Consultation Response from KC, Conservation & Design

2024/92365 Land off, Blackmoorfoot Road and Felks Street, Crosland Moor, Huddersfield, HD4 7AD

Date Responded: 21.10.2024

Boundary Details (Sheet 2)
 Blackmoorfoot Road,
 Huddersfield

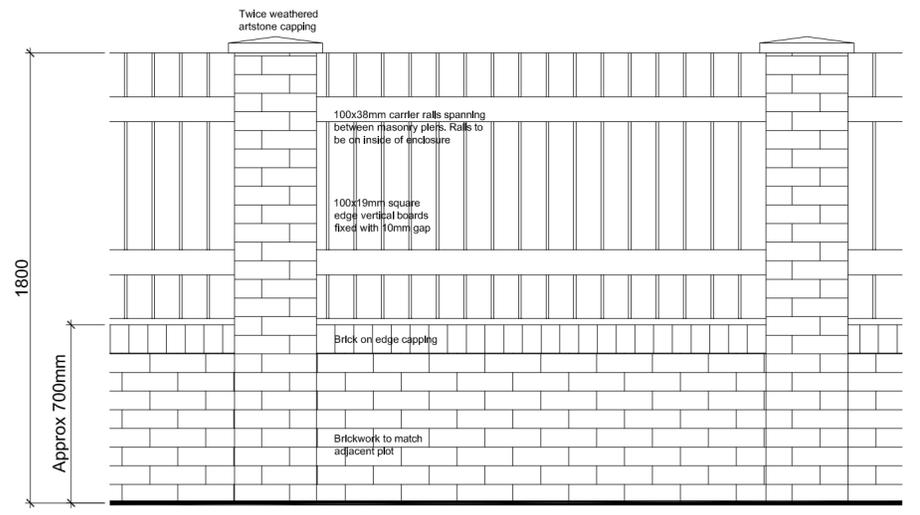
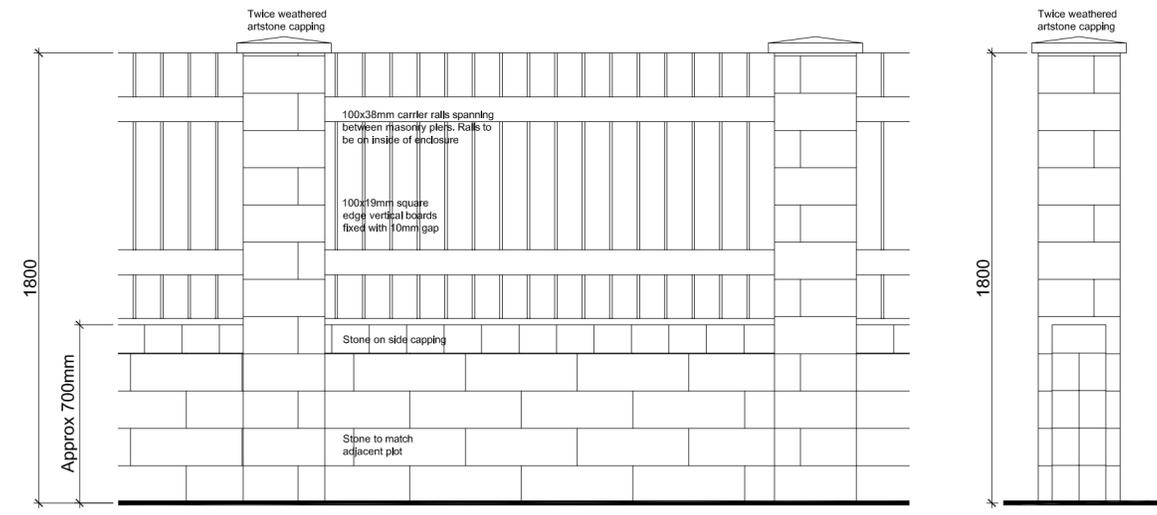
Further north along Crosland Hill Road, are the Grade II listed 41 and 43 Crosland Hill Road, and 67, 69 and 69a Crosland Hill Road, along with several unlisted historic buildings. A landscaped buffer provides some degree of separation between the proposed development and these listed buildings. 450mm high reclaimed stone boundary walls are proposed on the corner plots in this area, along with low knee rail fences.

Building materials along this boundary are reconstituted stone and red brick with grey roof tiles. The Conservation and Design Team would prefer natural stone and slate, along with dry stone walling on this boundary so that the development reflects the local character of this area. As there is a landscaped buffer between these dwellings and the historic settlement, a balanced judgement needs to be made.
